CITY OF ALBUQUERQUE

Re: McMahon Marketplace Taproom
5720 McMahon Market Place NW
30-Day Temporary Certificate of Occupancy- Transportation Development
Transportation Development Final Inspection
Engineer's/Architect's Stamp dated 8-25-17 (A11D011H)
Certification dated 04-27-18

A1.2

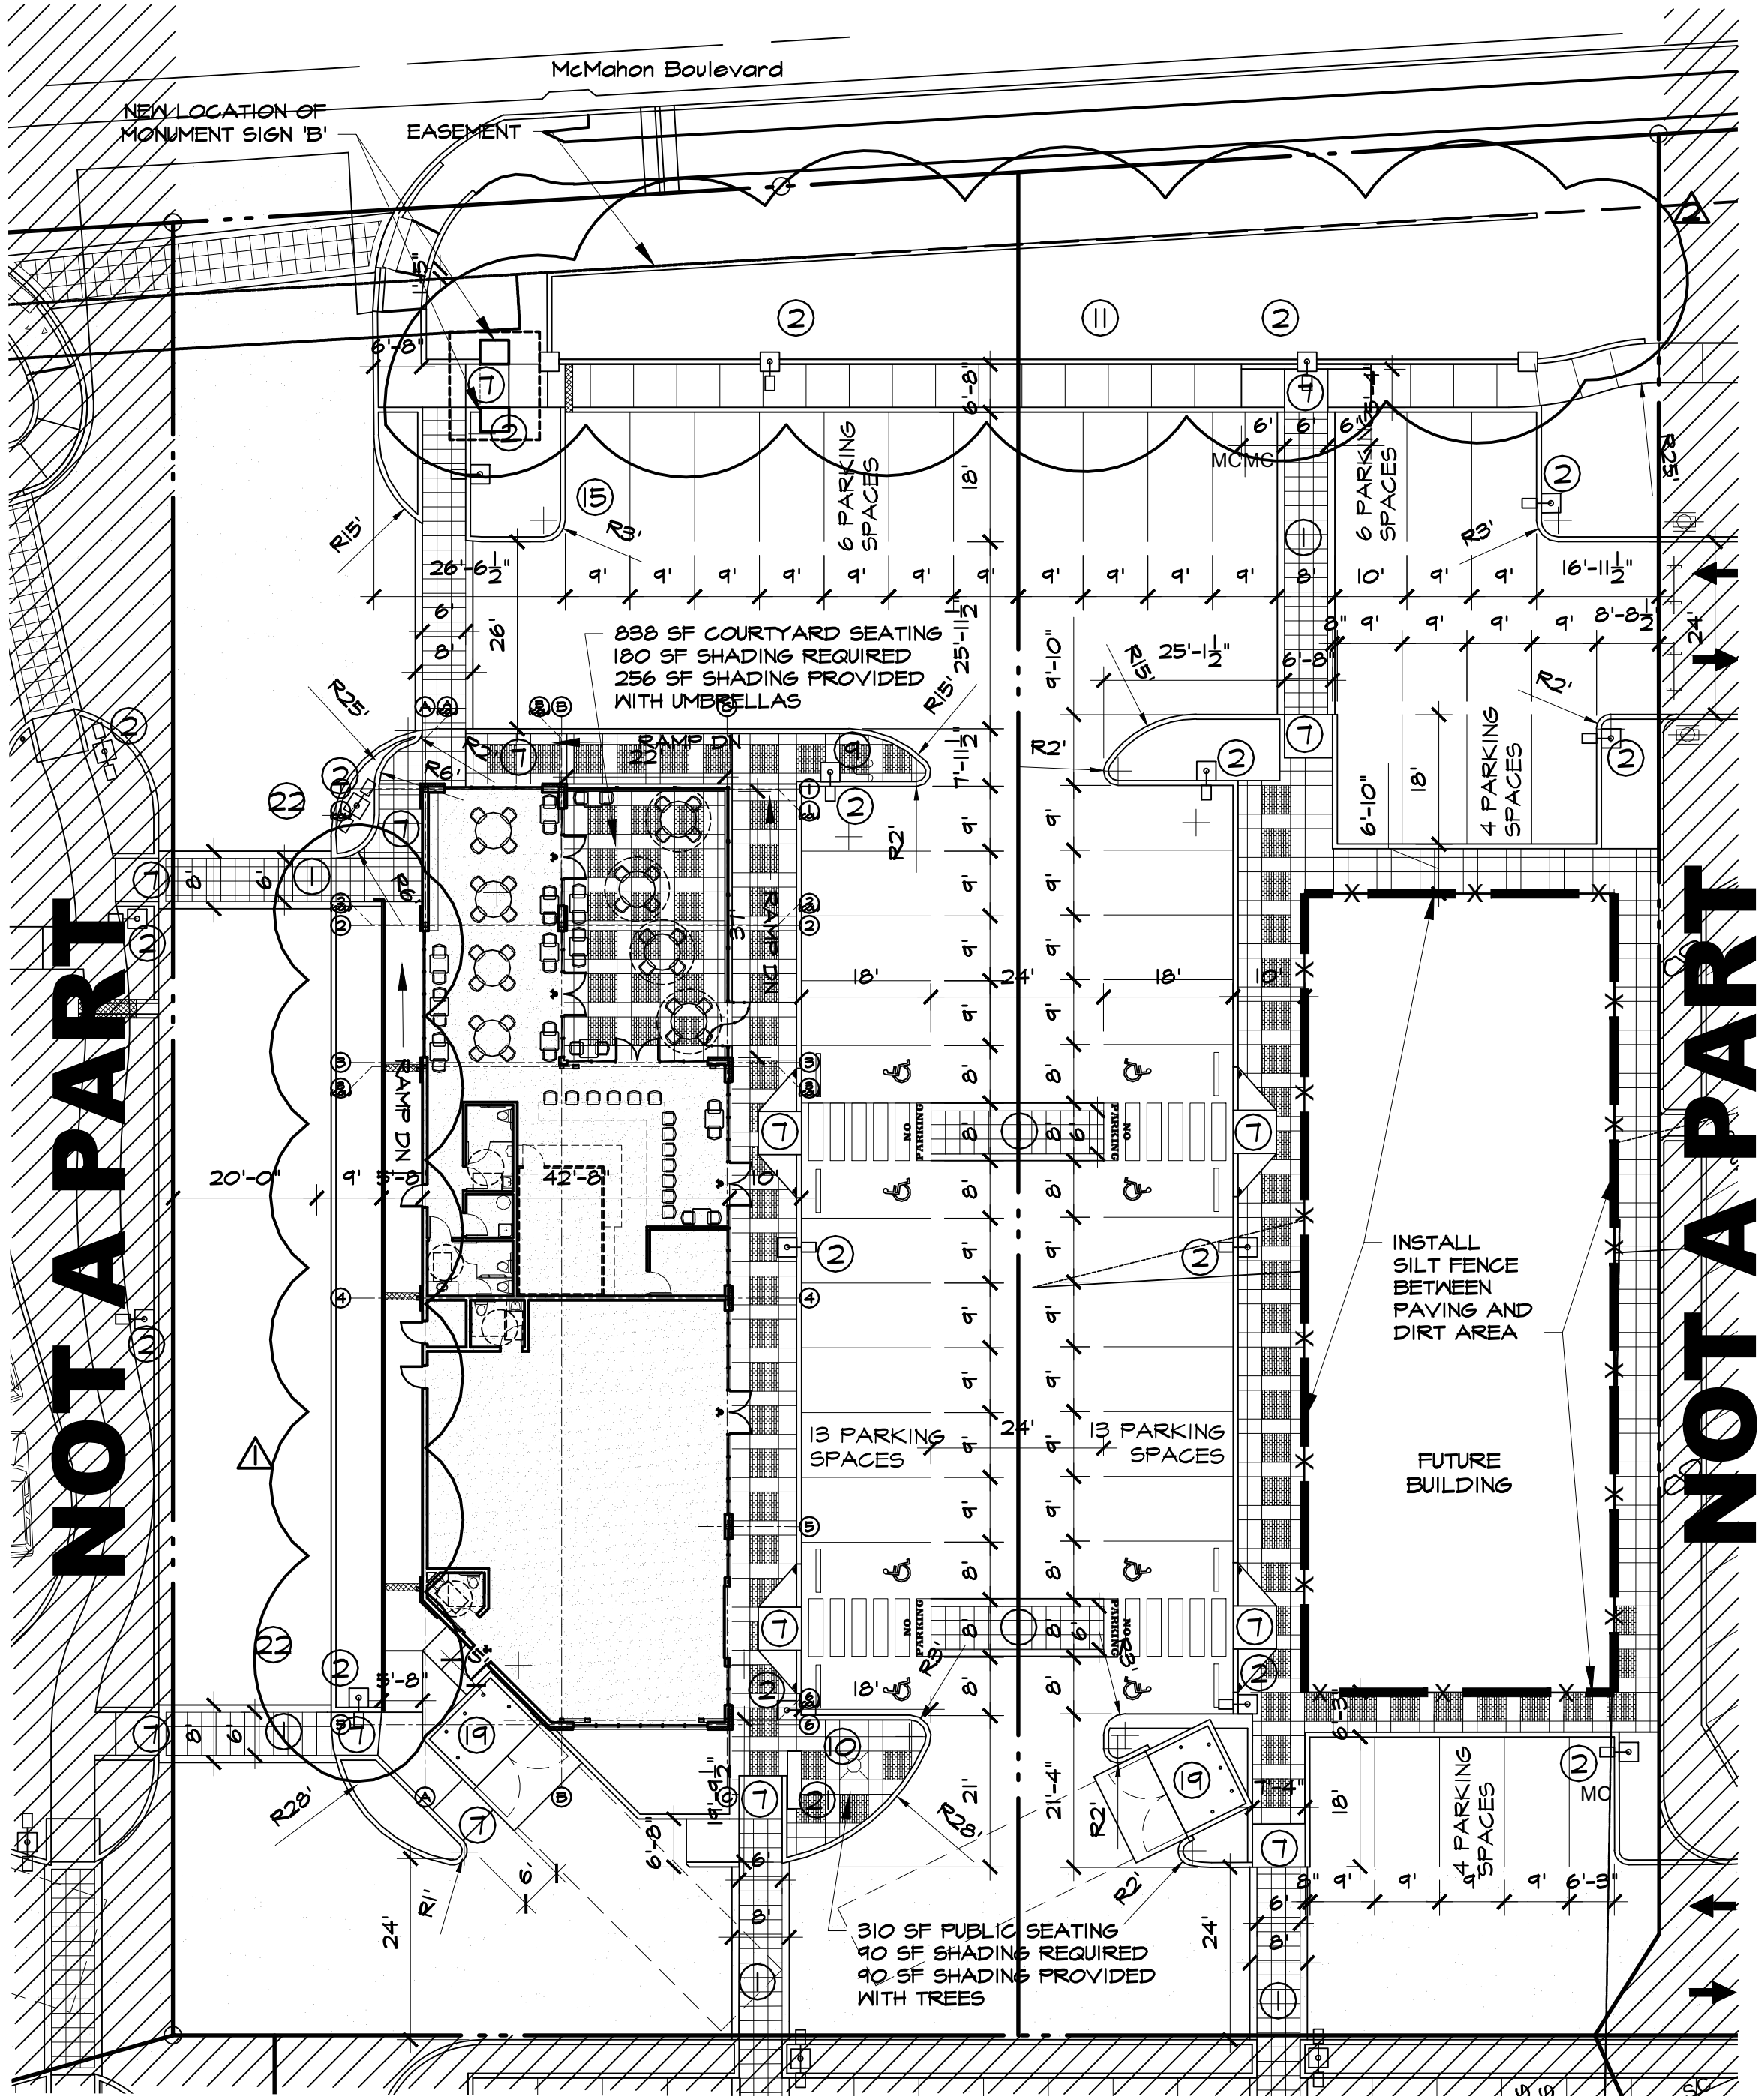
1. Missing Motorcycle parking signs.
